Our ref: WA/2015/120747/01-L01
Your ref: 15/00839/REM
Date: 03 July 2015

**Reserved matters to 05/01337/out - 125 residential units on parcels D and E
Longford Park, Parcel D And E, Phase 3, Longford Park Road, Bodicote**

We have reviewed the following documents:

- Microdrainage calculations for Parcels D and E, dated May 2015.
- Bovis Homes drainage strategy drawing number 0120-2-600, dated May 2015.

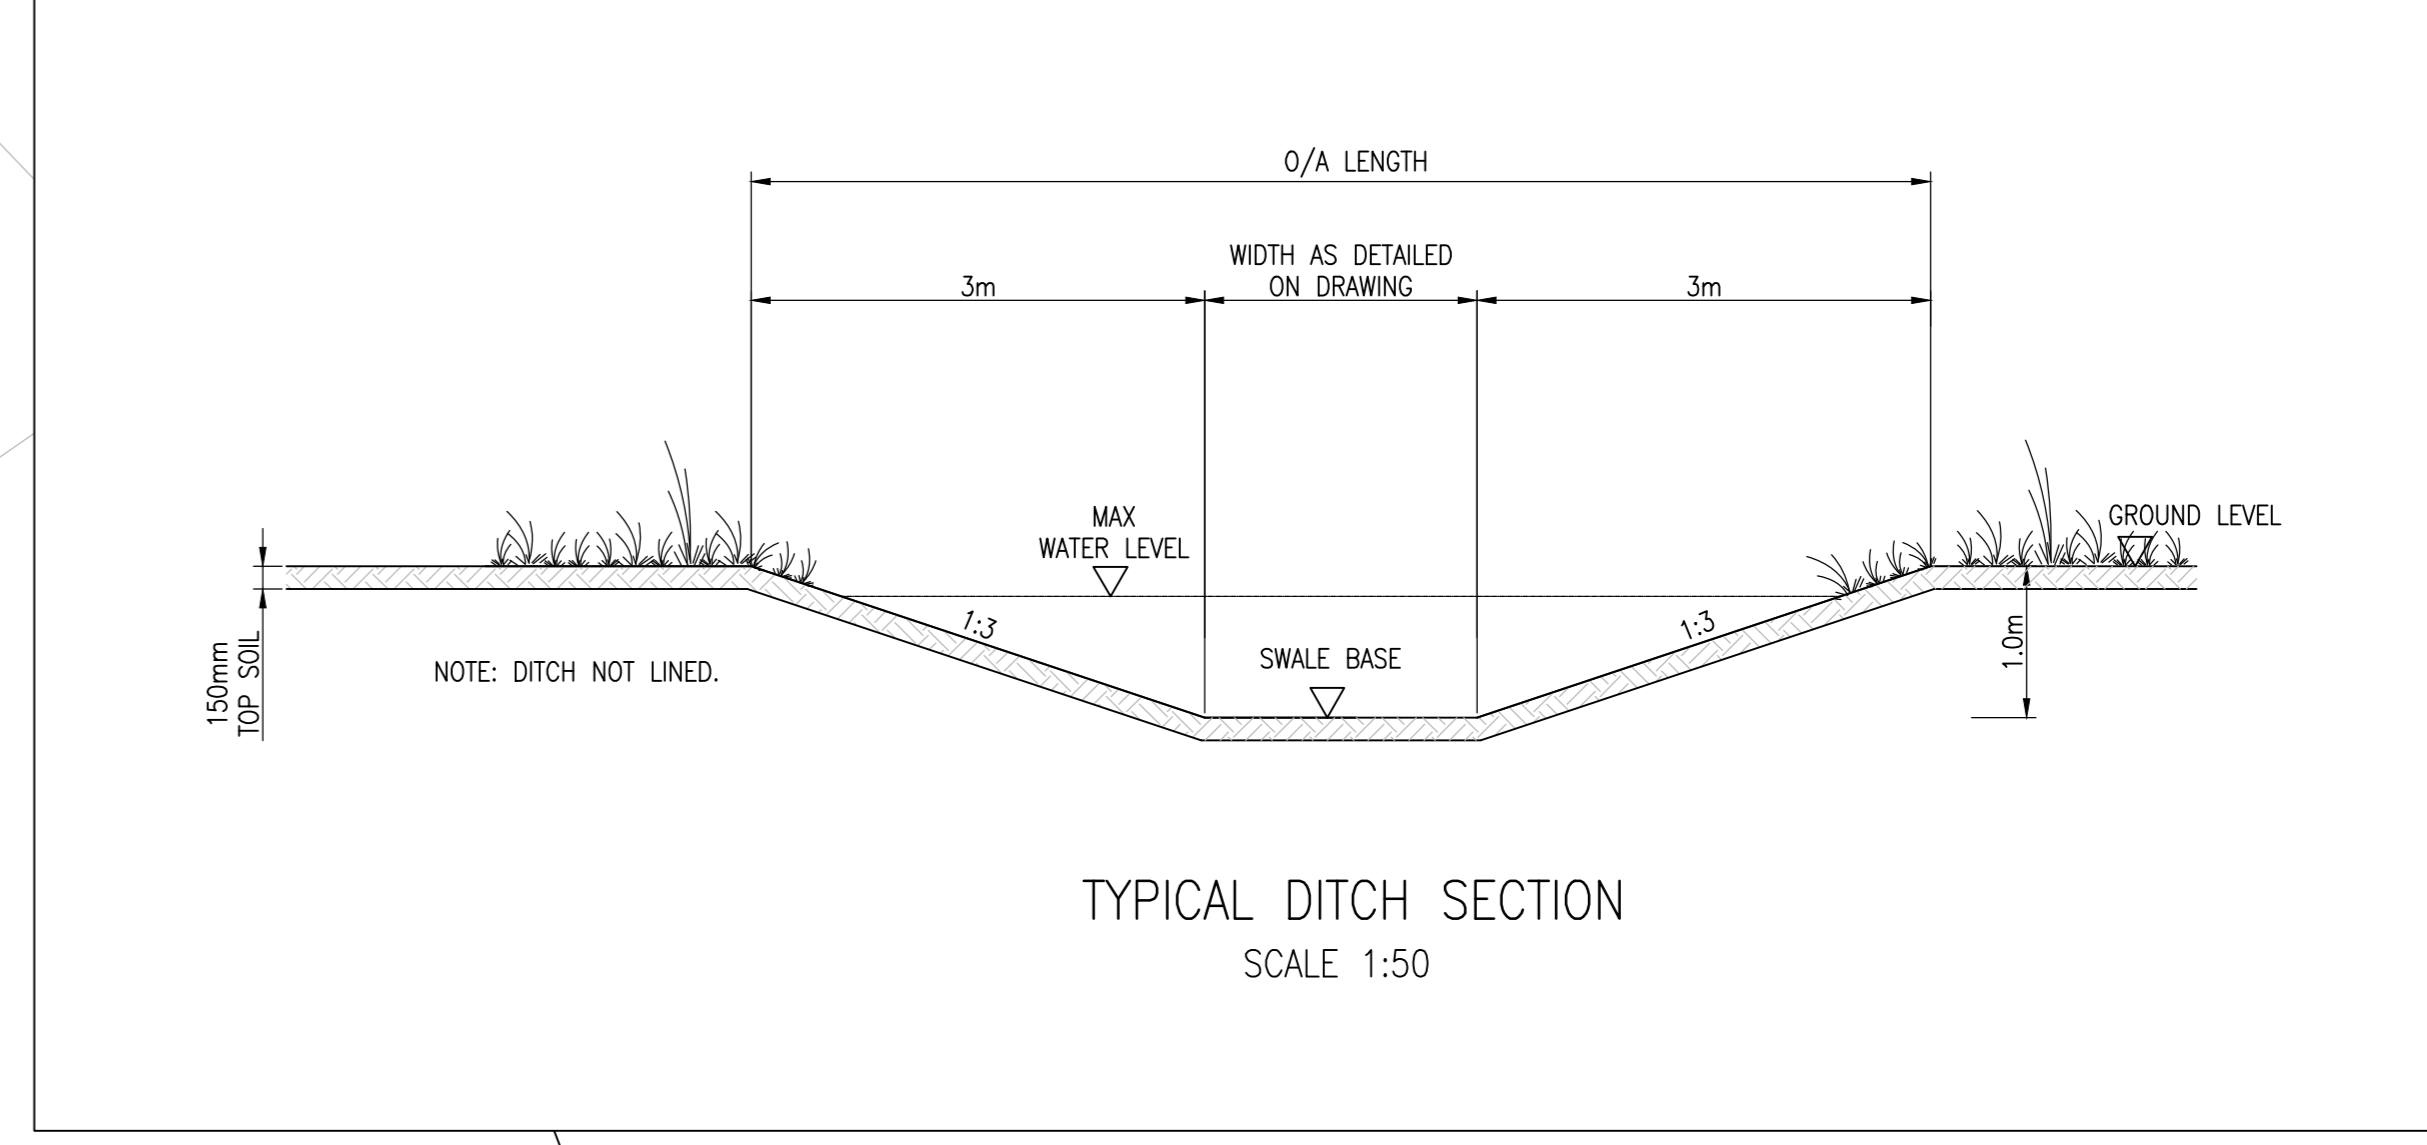
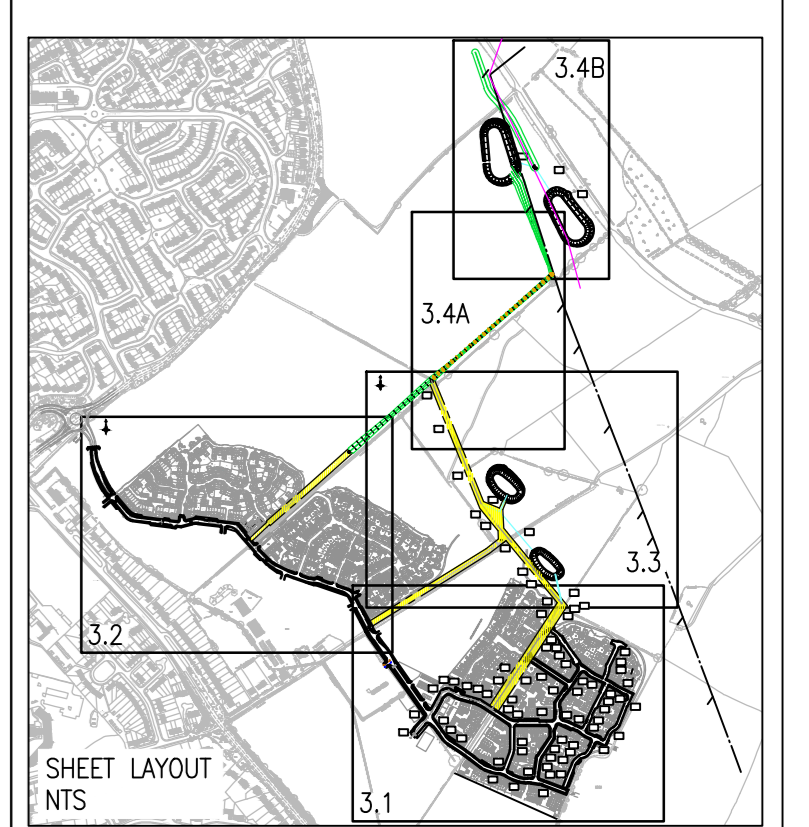
However, it is unclear from the drainage strategy drawing how the drainage network links to the overall drainage strategy for the site. We request that the applicant demonstrate on the drainage strategy drawing how the different network fits in with the outline drainage strategy.
